3 February 2021
 Our Ref: 2517 / DPIE Ref: SSI-9487

RE: Submission in relation to the Inland Rail – Narromine to Narrabri (SSI-9487)

Prepared by:	Jim Lawler, Associate, Groundwork Plus Pty Ltd PO Box 1779, Milton BC QLD 4064 P: 07 3871 0411, M: 0406 680 969, E: jlawler@groundwork.com.au
On behalf of:	Regional Quarries Australia Pty Ltd
In relation to:	Inland Rail – Narromine to Narrabri (SSI-9487)
Submission:	Objection
Reasons:	<ol style="list-style-type: none"> 1. Chapter C3 of the N2N EIS identifies exceedances of noise, vibration and air quality criteria for the operation of the borrow pits which would not ordinarily be acceptable for an Extractive industry. 2. The N2N EIS has not considered whether dust from the resource at the borrow pits could result in a human health risk for respirable crystalline silica. 3. The borrow pits for the N2N should be held to the same assessment criteria and operational obligations as a commercial quarry operation. 4. The N2N has not considered the most likely haulage routes for quarry materials from existing quarries in Dubbo and should be revised to include an assessment of impacts of construction traffic on the Mitchell Highway, Tantitha Roa

Figure C3.1 Indicative layout - borrow pit A (Tantitha Road, Narromine)

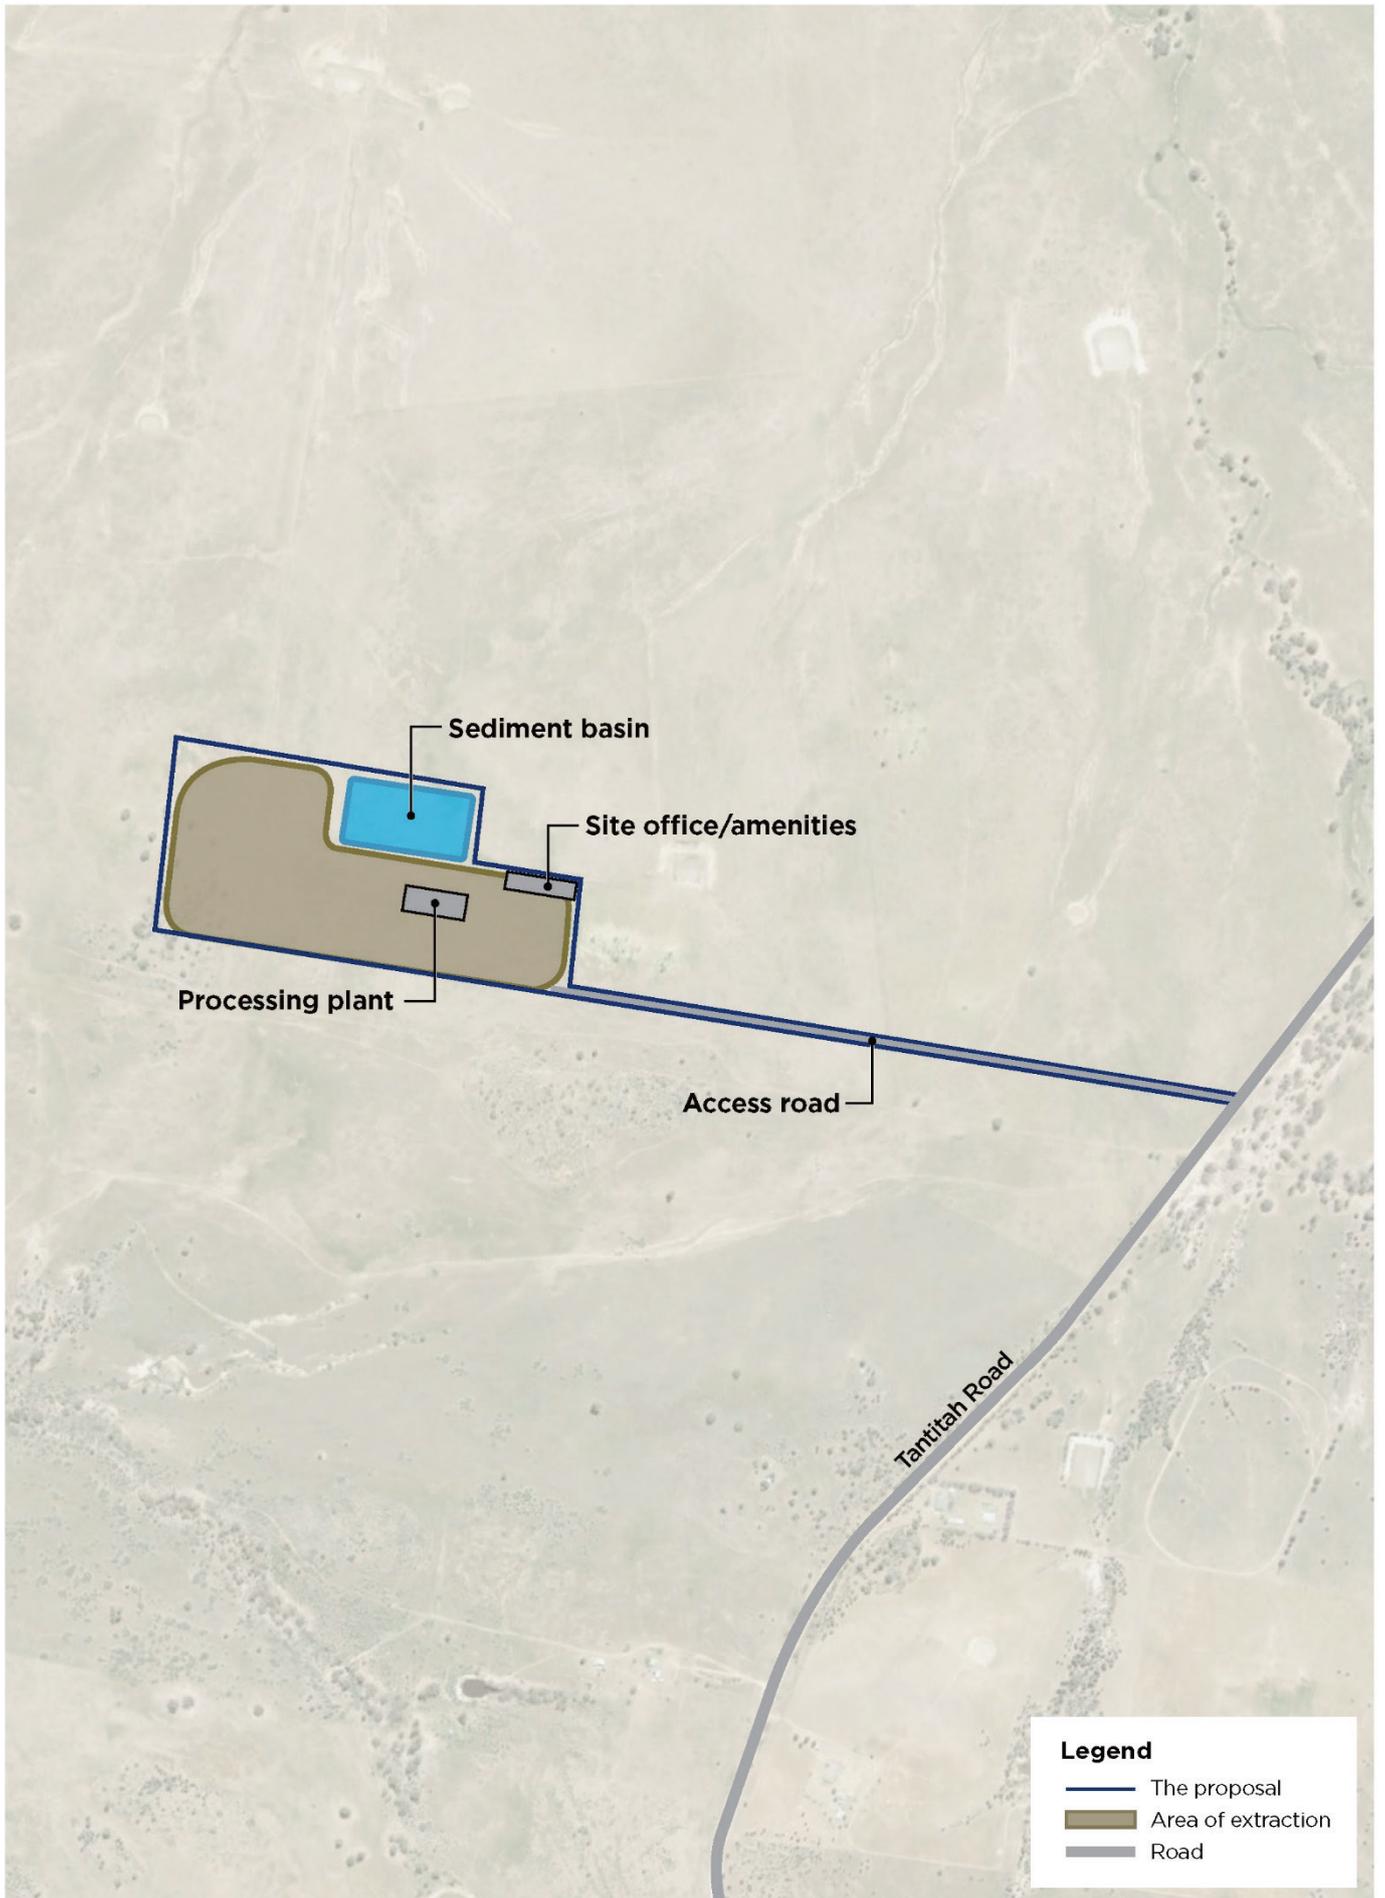
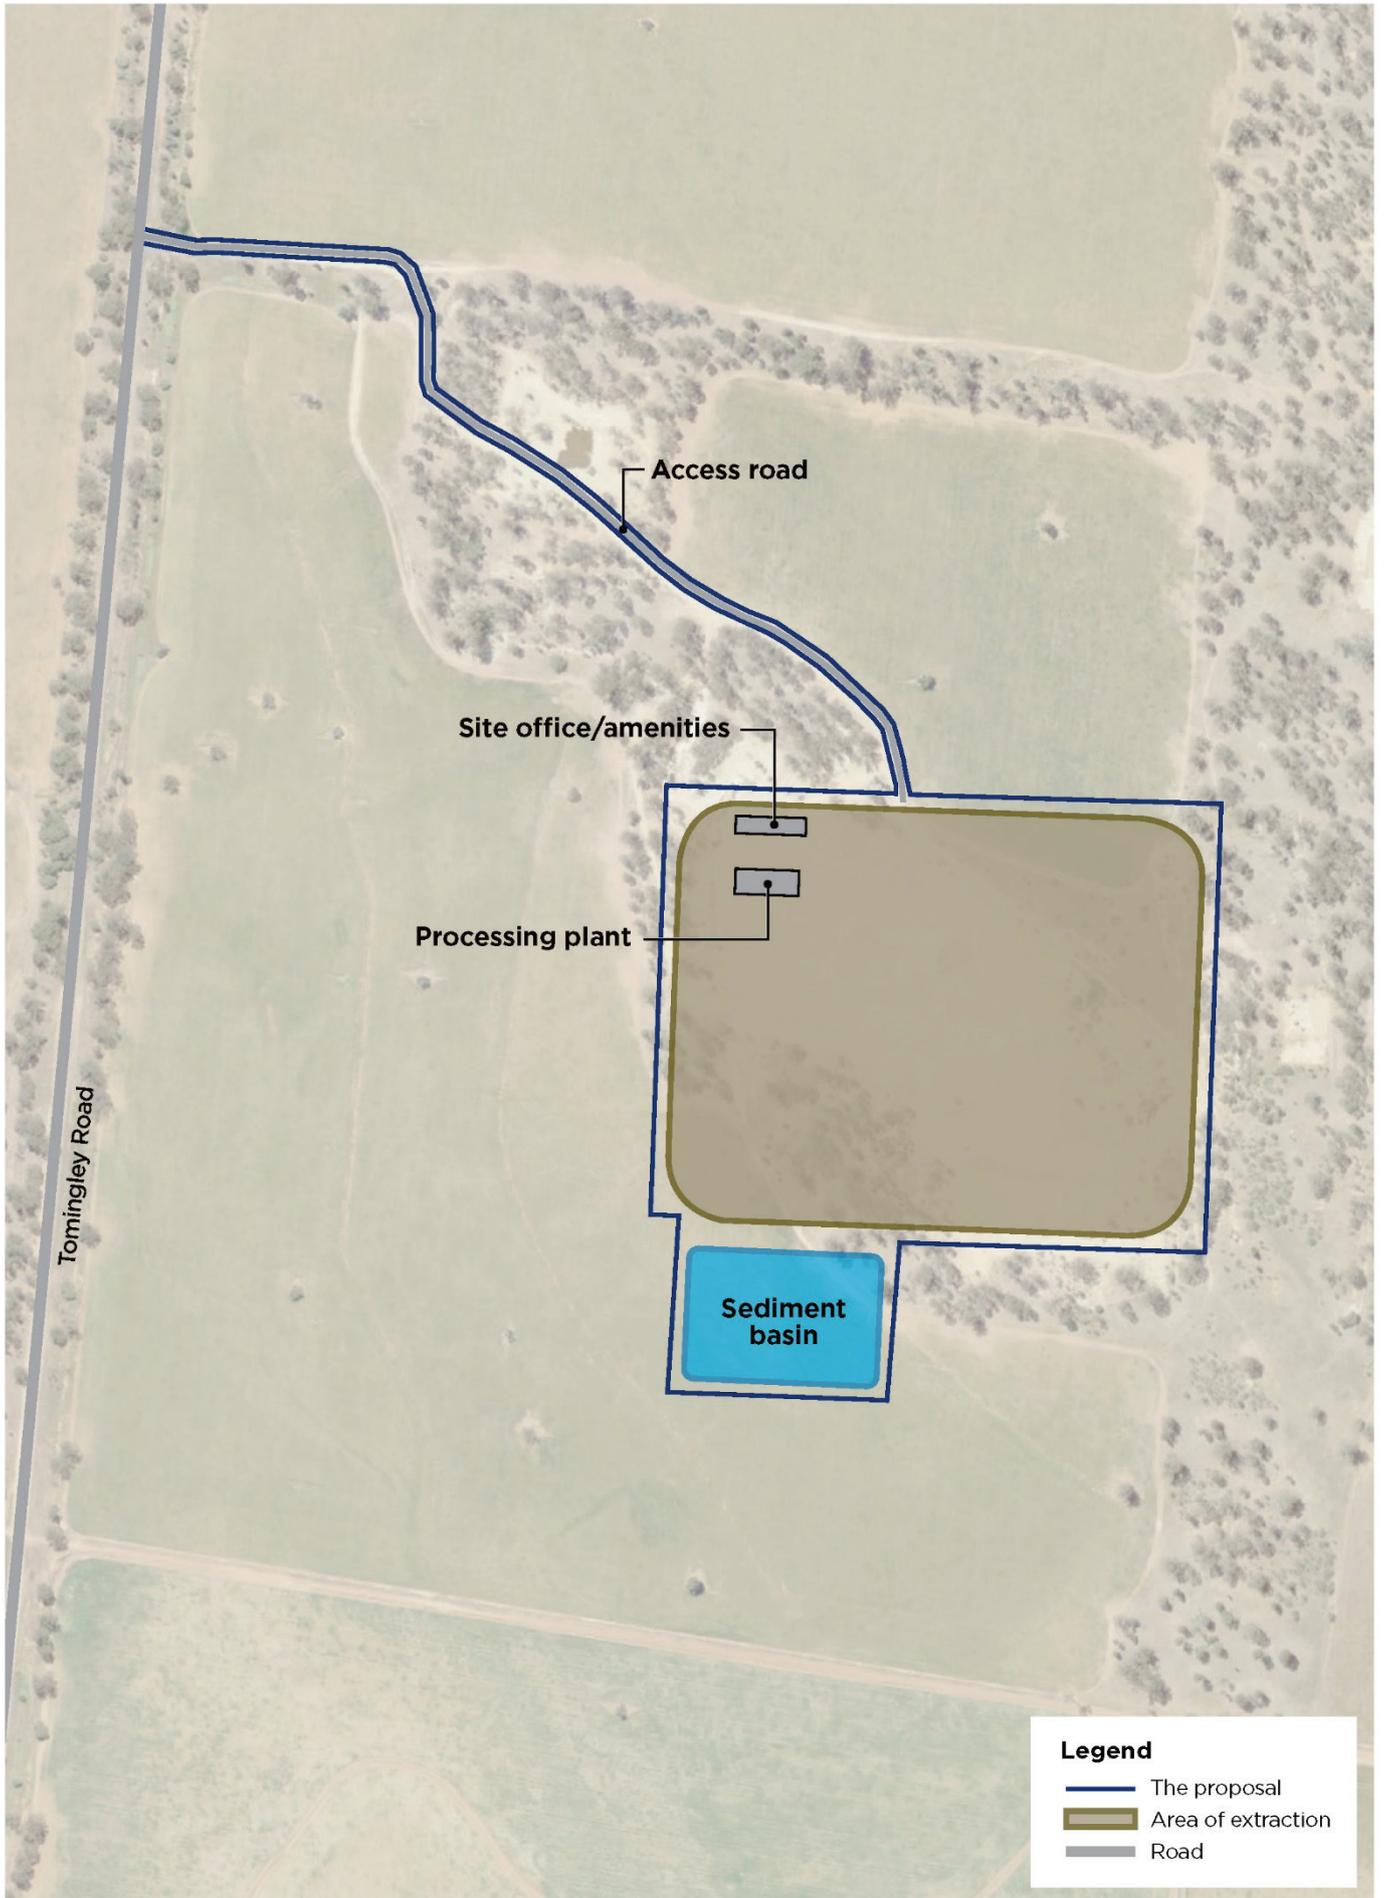
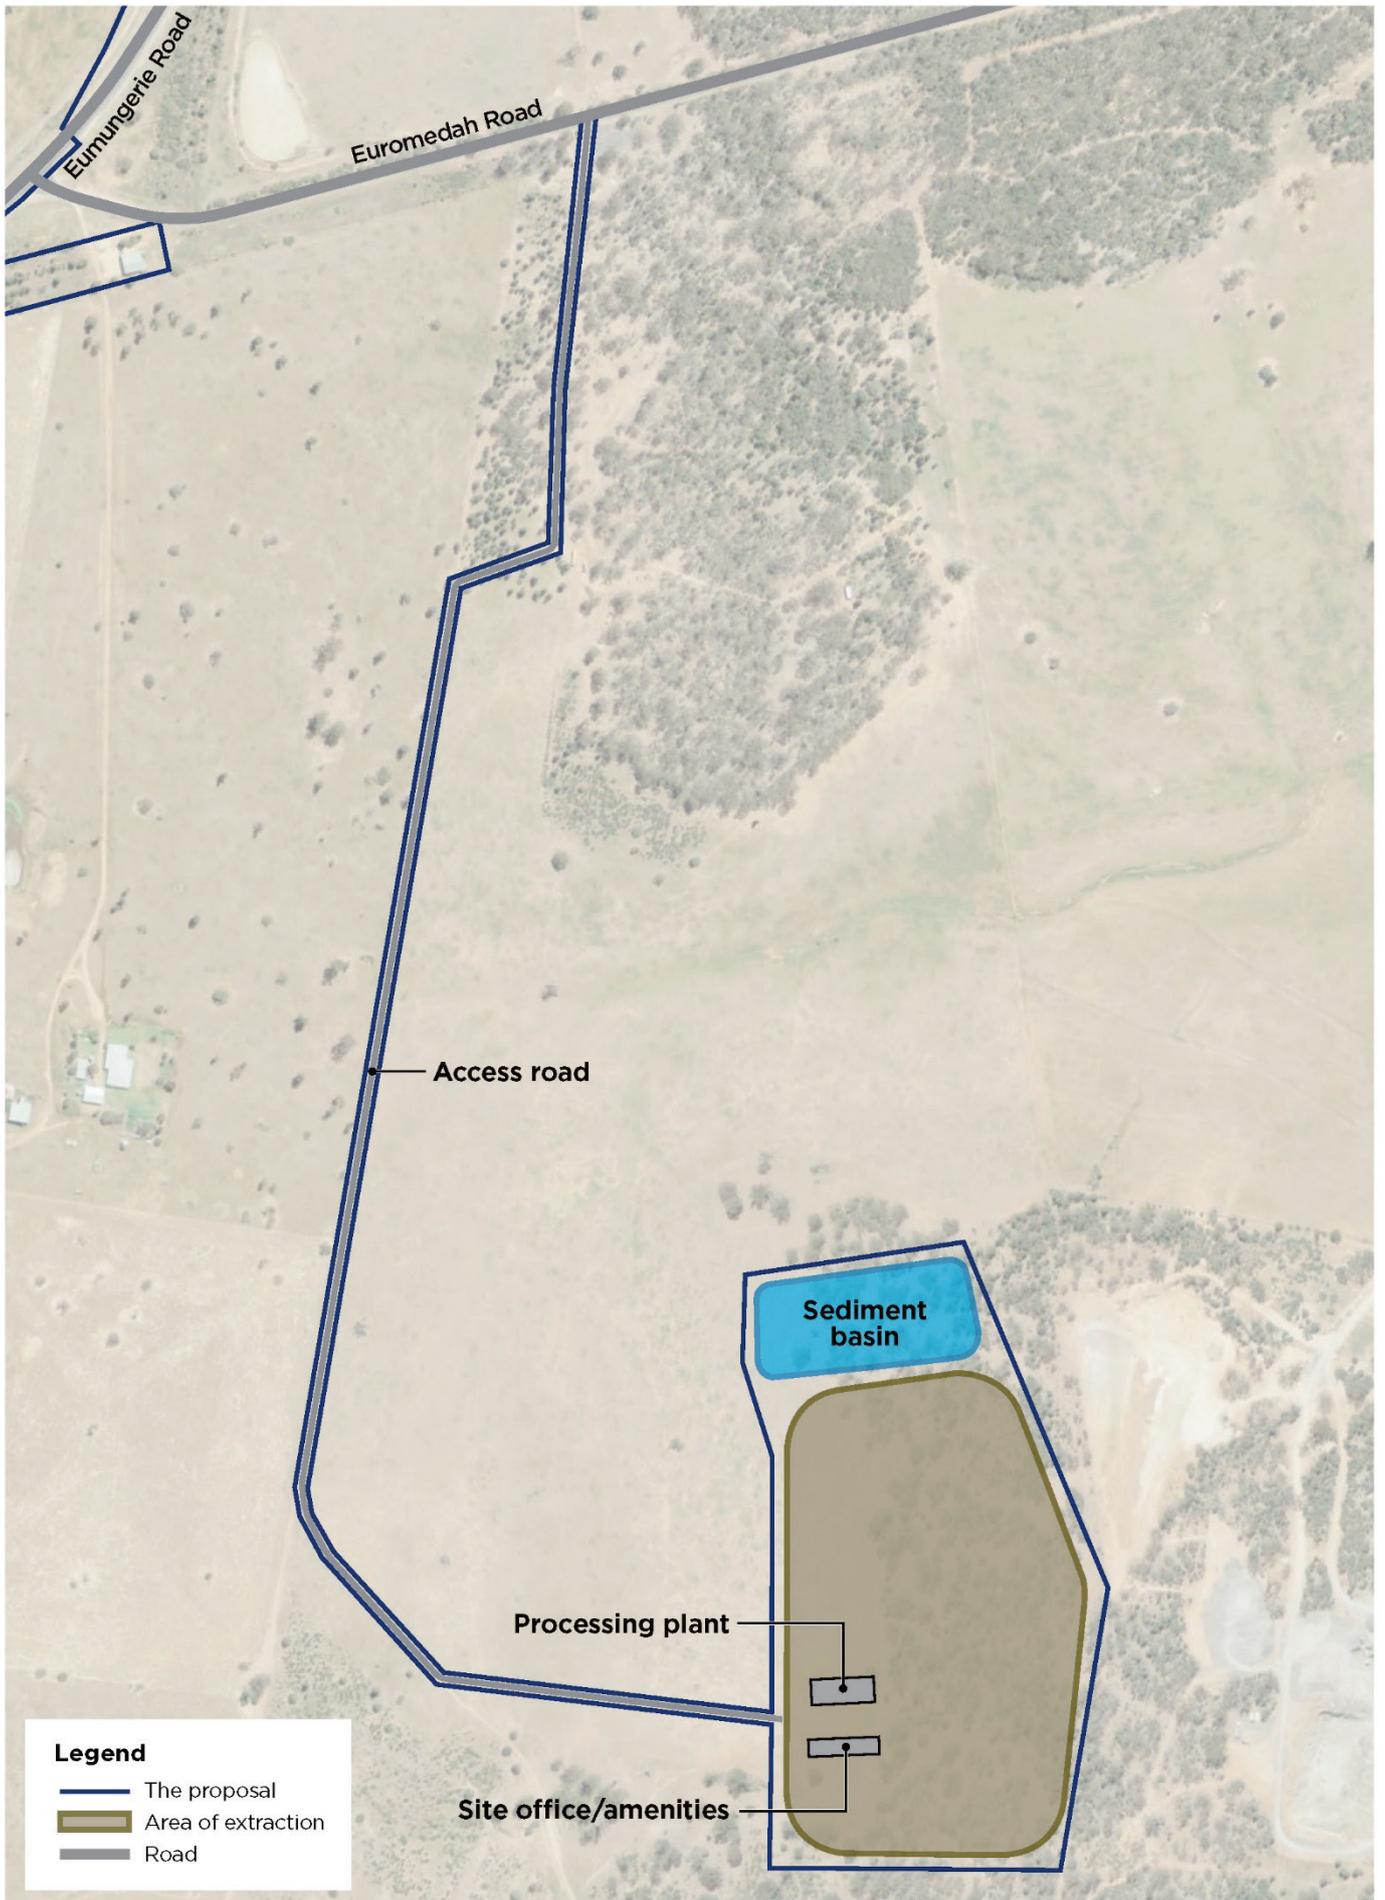
9. Borrow pit development plans are not sufficiently detailed.

The indicative layouts of the borrow pits provided in Chapter C3 of the N2N EIS do not provide the same level of detail ordinarily required for extractive industry. For example, a maximum depth of extraction is not identified, batters and benches of the extraction area are not identified and neither is the finished surface level. More detailed proposal plans should be provided to ensure adequate information is available to facilitate assessment of the potential impacts of the borrow pits and to assist in compliance investigations in the future.
